2 September 2022

TfNSW Reference: SYD19/01350/46

Departments Reference: SSD- 10448 – MOD 2

AMMENDED APPLICATION - SECTION 4.55 MODIFICATION TO ASPECT INDUSTRIAL ESTATE, WAREHOUSE 9 - 804-882 MAMRE RD, KEMPS CREEK

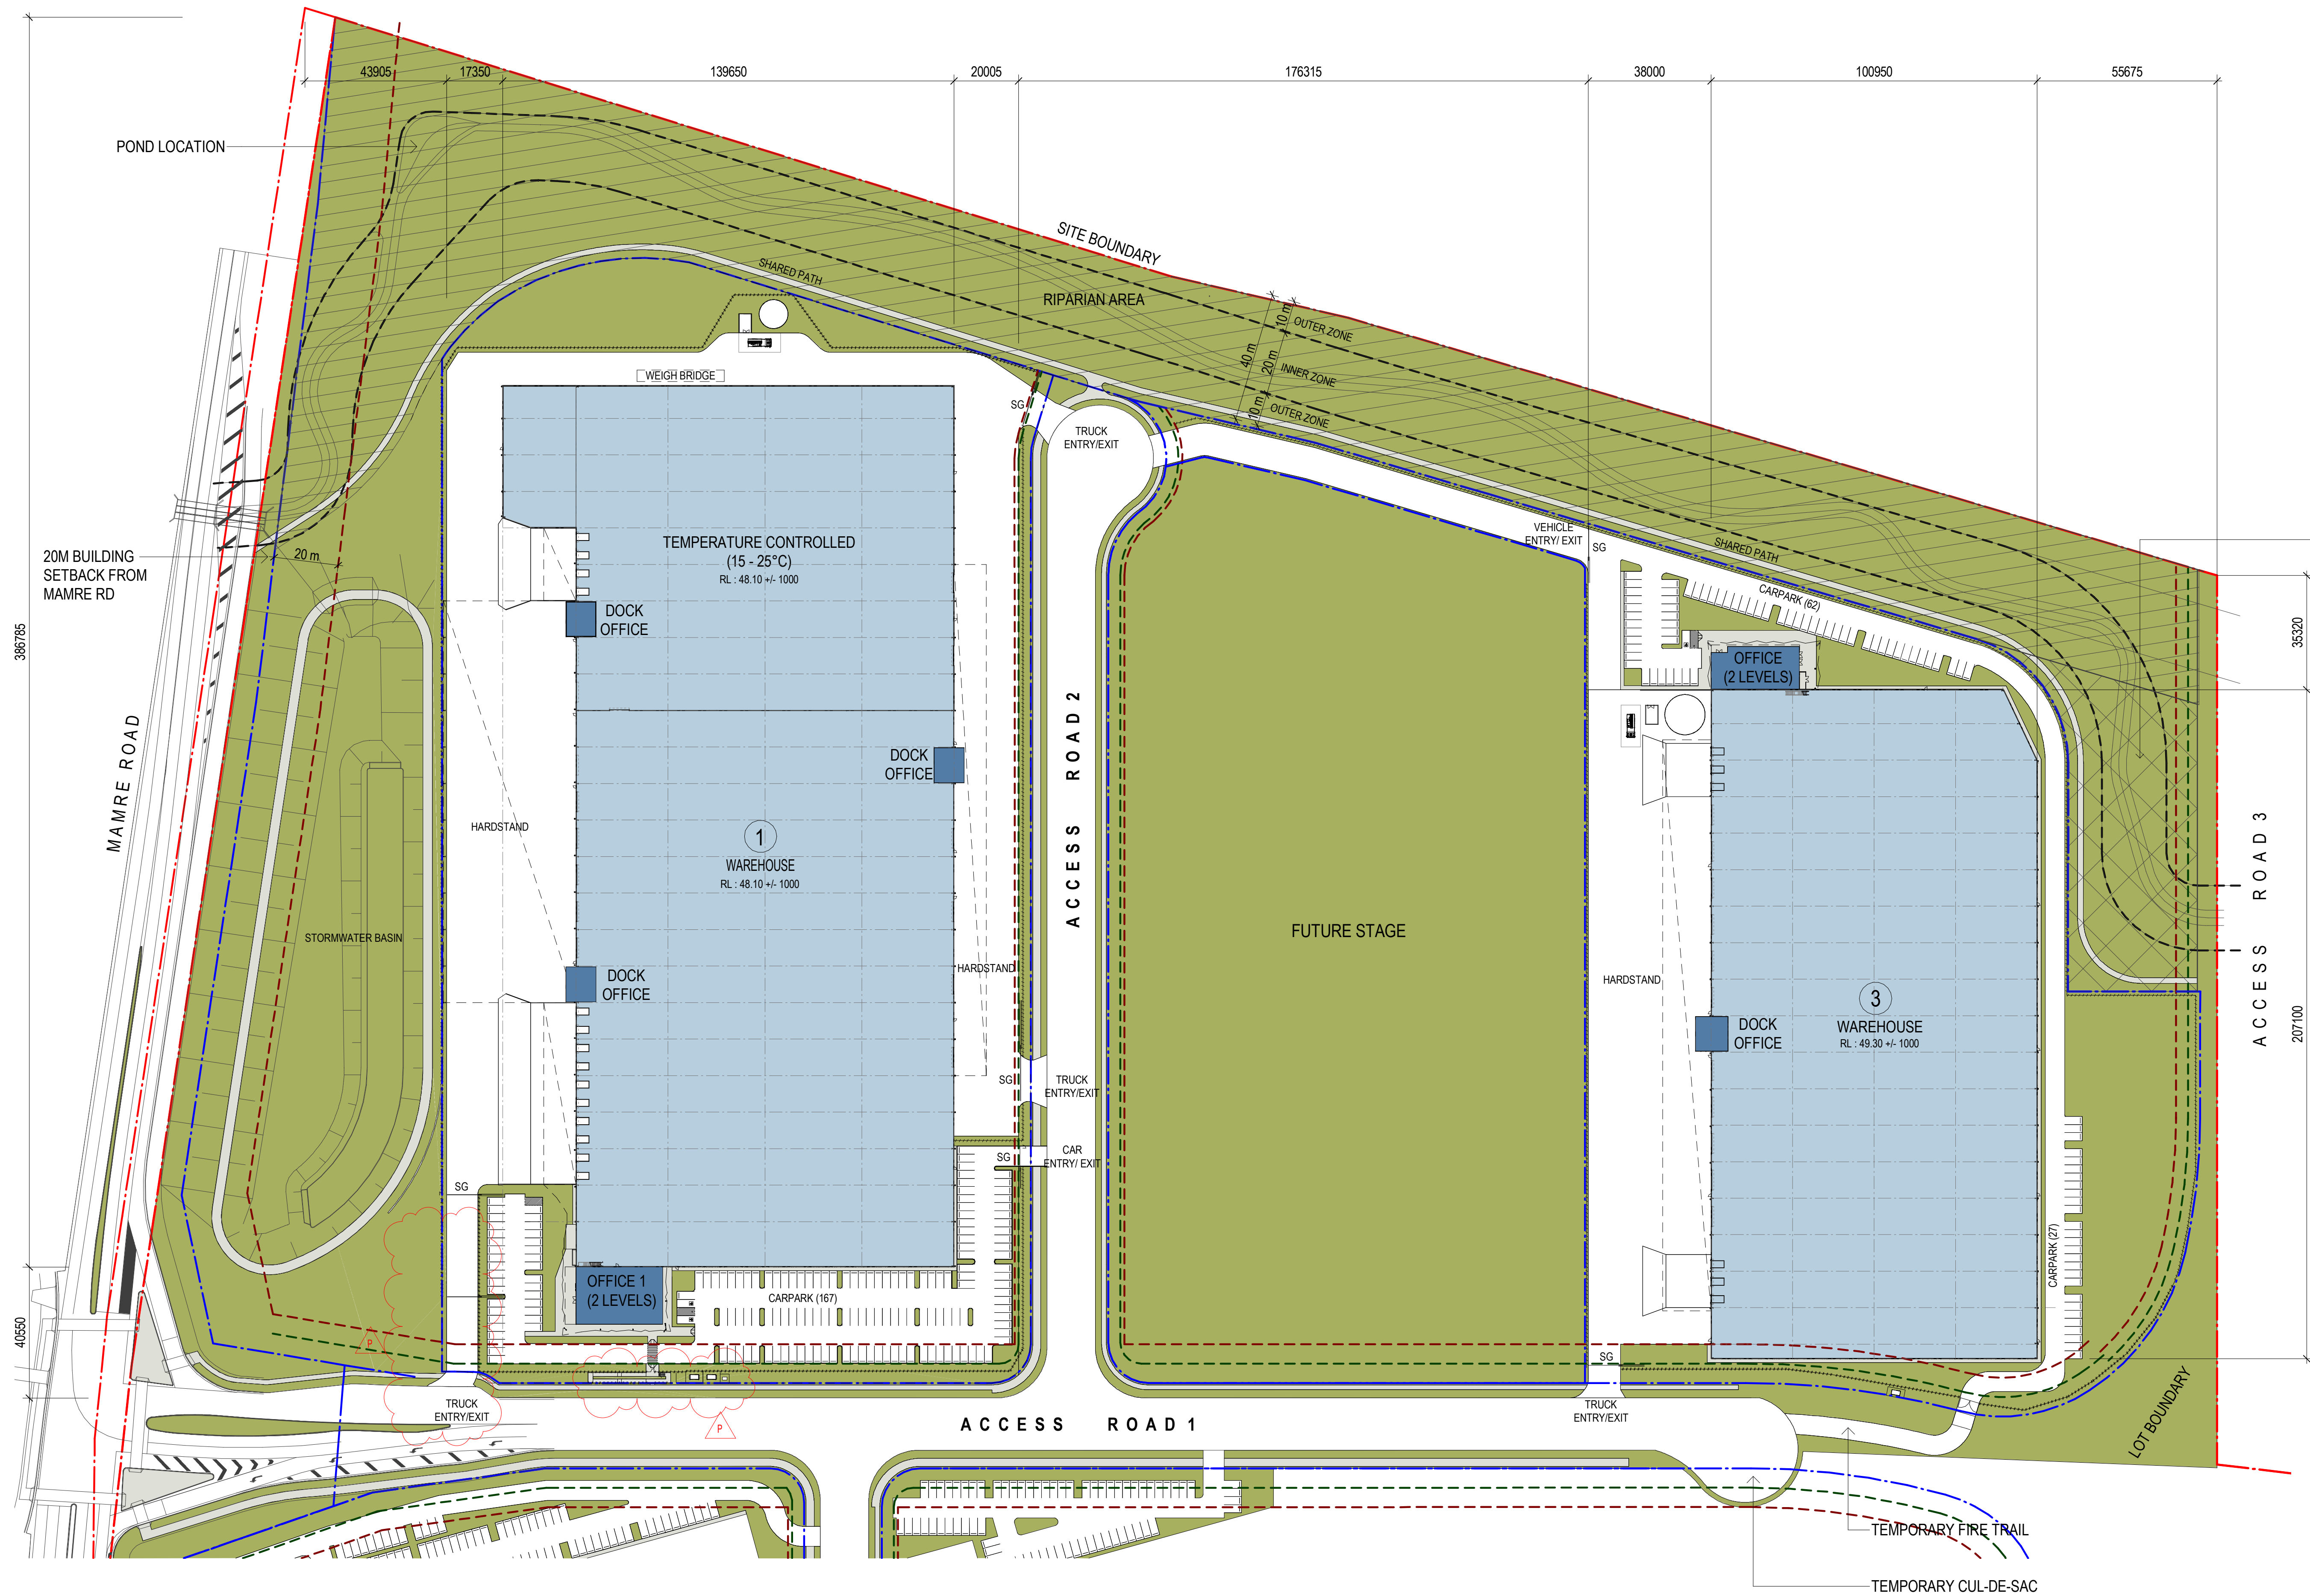
TfNSW notes that the proposed modifications to the Warehouse 1 built form include revised vehicular access arrangements with a 9.6m wide truck entry/exit way off Access Road 1 and two truck entry/exit ways off Access Road 2.

TfNSW does not support the proposed left turn deceleration lane into Warehouse 1 due to the proximity to the signalised intersection of Mamre Road/Access Road 1. TfNSW provides the following comments to expand on the safety issues:

1. TfNSW is concerned with the close proximity to the traffic signals and impacts to its safe and efficient operation. A heavy vehicle that uses the driveway will be approaching at a very low speed due to the size of the vehicle, short deceleration lane and high angled entry. In addition, the short length and width of the deceleration lane does not adequately accommodate for a 26m B-double or 36.5m PBS Level 3 type A vehicle and therefore long vehicles will not effectively utilise the lane.

This can result in rear-end crashes and traffic banking to the traffic signals. The consequences are a loss of efficiency at the intersection and the deterioration of the Level of Service for vehicles attempting to enter the Estate from Mamre Road. This issue is apparent for both the left turn and right turn approaches to Access Road 1.

2. The approved Mamre Road upgrade Stage 2 strategic plans indicate a dual right turn from Mamre Road into Access Road 1. TfNSW raises concerns with potential conflict of vehicles turning right from

Mamre Road (in the ultimate arrangement of dual right turn) and changing lanes to access the deceleration lane (very close to signalised intersection). This could lead to potential side swipe issues and queuing into the intersection. It is also considered that the slow movement of a heavy vehicle will lead to adverse intersection efficiency impacts when merging across lanes to access the entrance to Warehouse 1 hardstand.

Based on the above issues raised, TfNSW considers Condition D11 shown below has not been satisfied to TfNSW requirements.
